December 23, 2019

RE: **Francisco Lopez Residential  
Bridge/Eucariz SW  
Request for Pad Certification – Not Accepted**  
• **Lots 1-6**  
**Grading Plan Stamp Date: 9/25/12**  
**Certification Dated: 12/13/19**  
**Hydrology File: L11D067**

Dana Peterson  
Senior Engineer, Planning Dept.  
Development Review Services

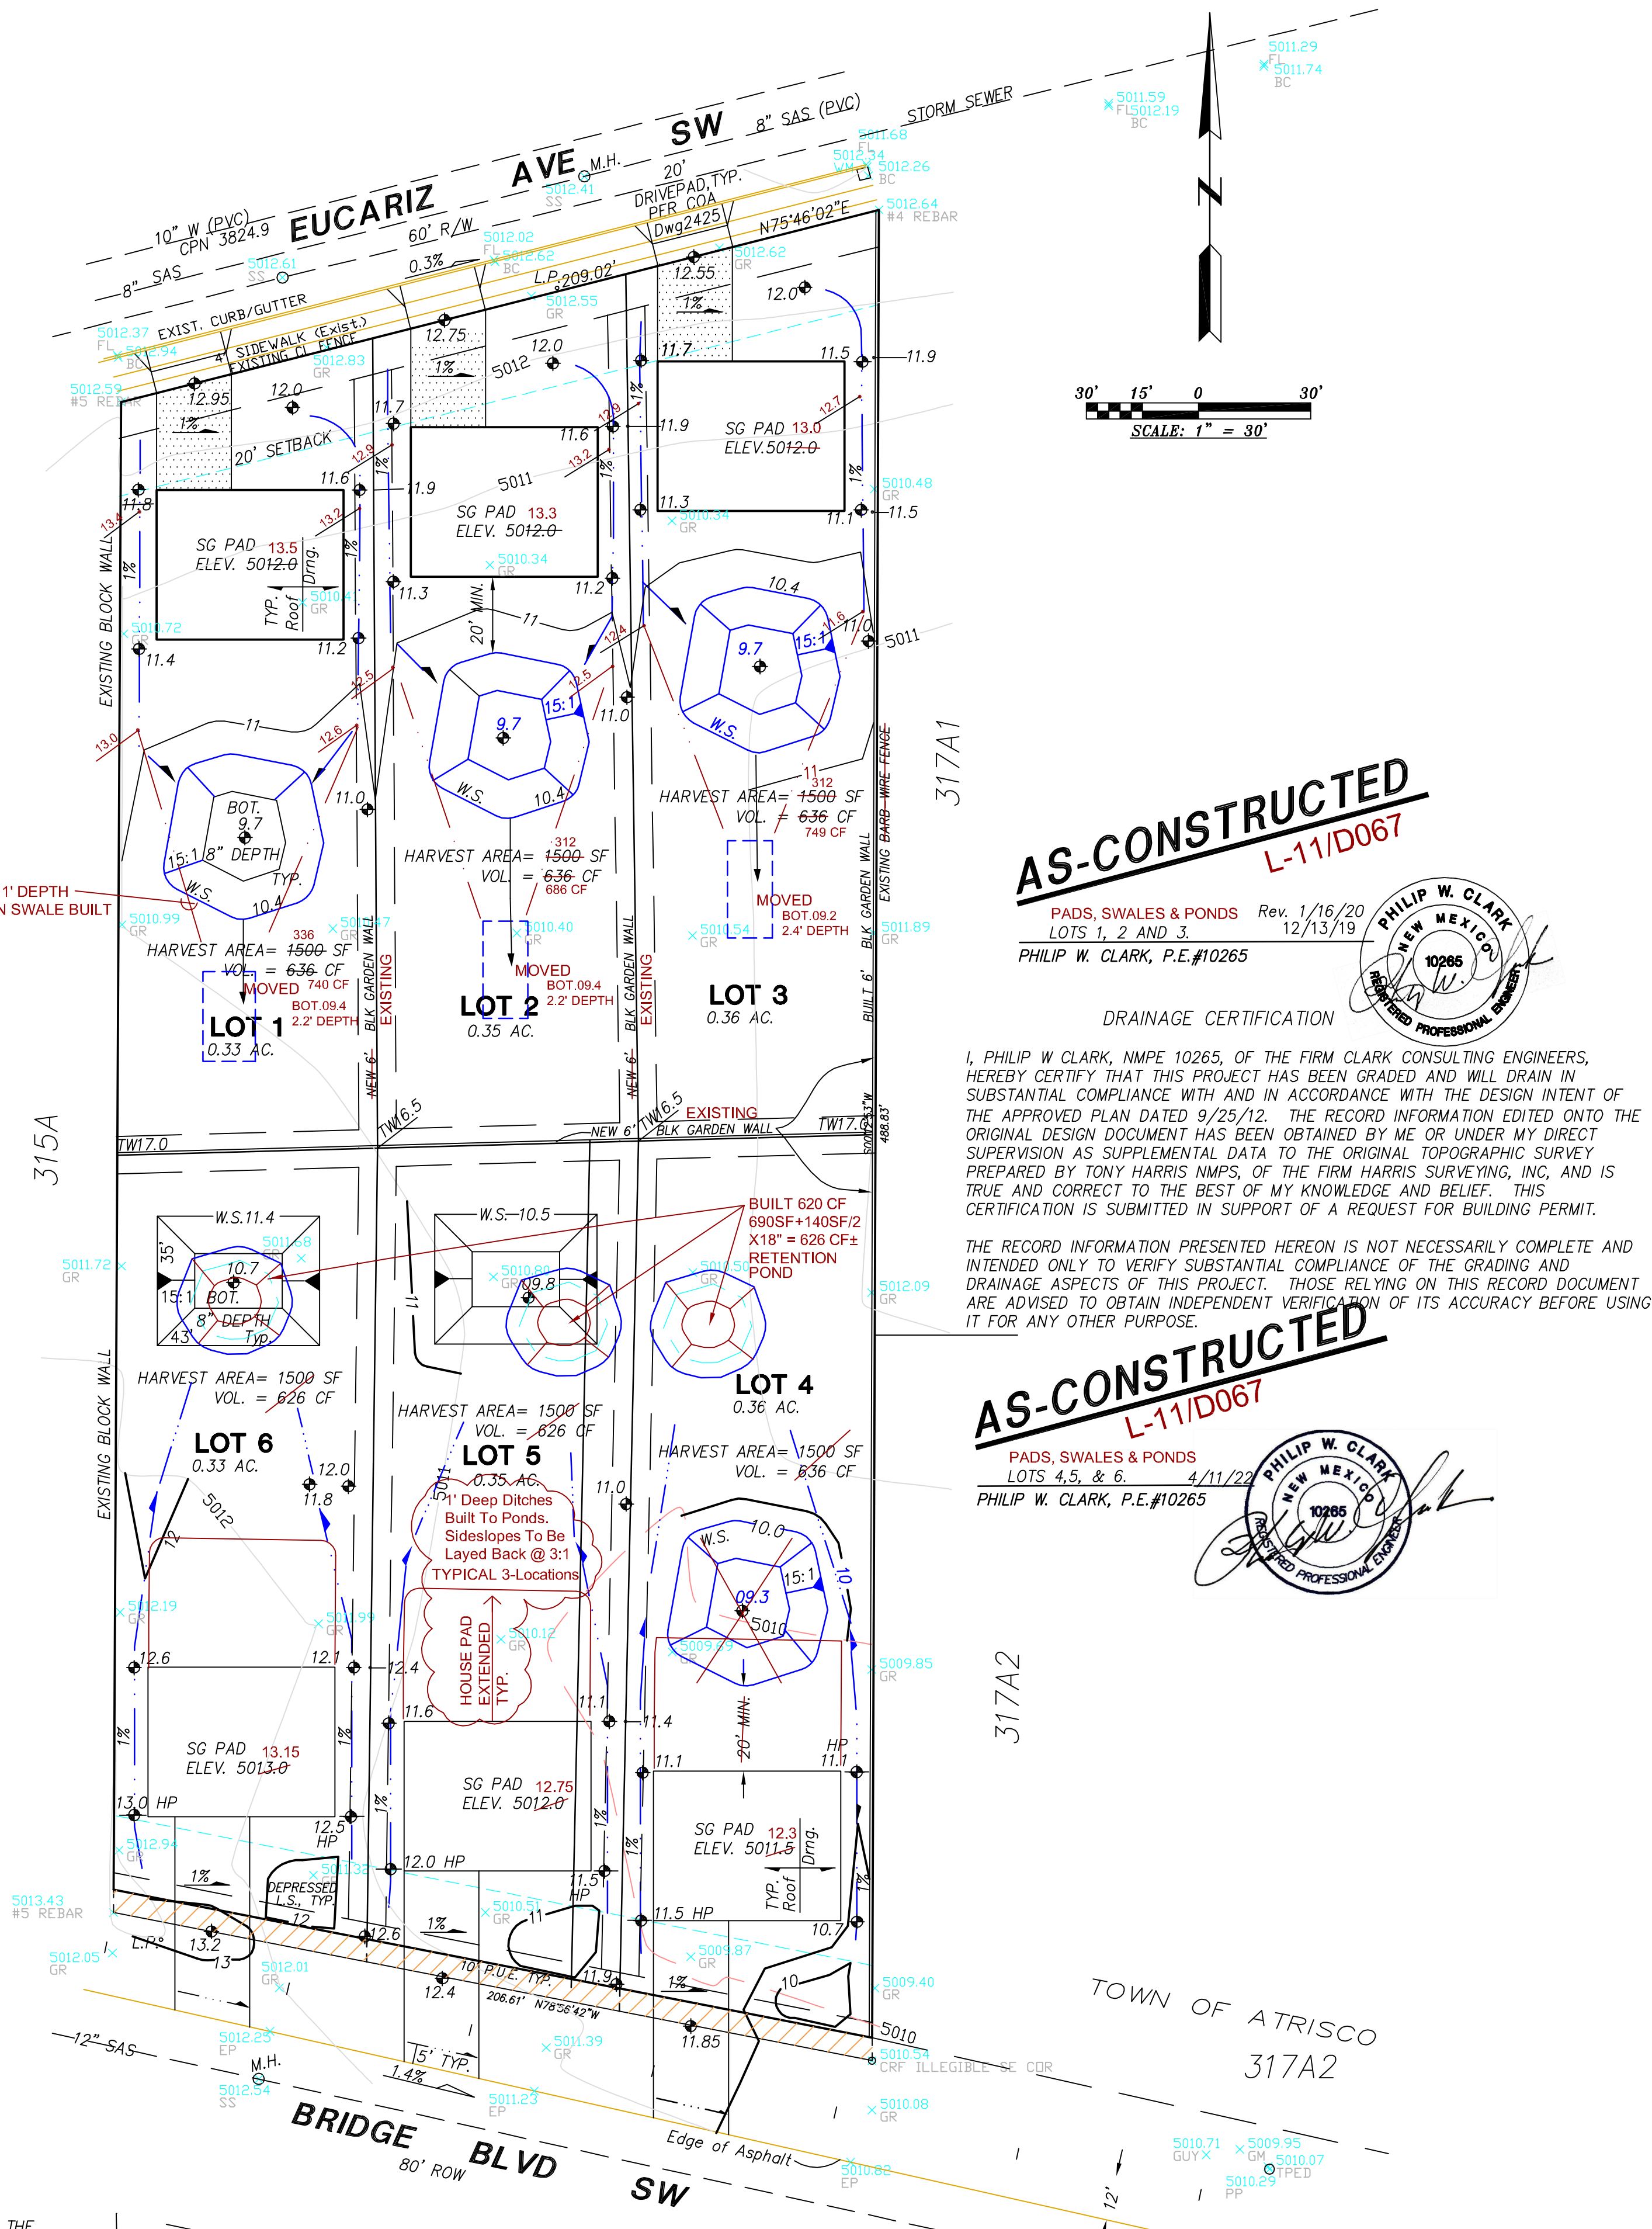
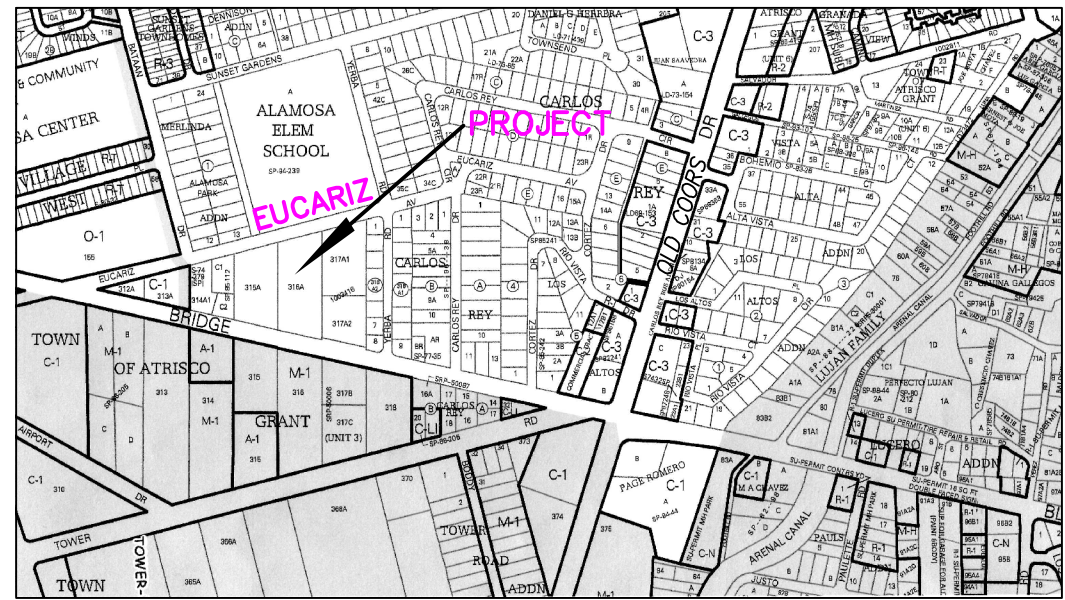
1. Use the Drainage Certification Language, per the DPM Chapter 22.7: *DRAINAGE CERTIFICATION WITH SURVEY WORK BY PROFESSIONAL SURVEYOR* or *DRAINAGE CERTIFICATION WITH VERIFICATION BY ENGINEER OF RECORD*; be sure to include surveyor information.
2. The ponds need to be constructed and surveyed, per the approved Grading Plan.
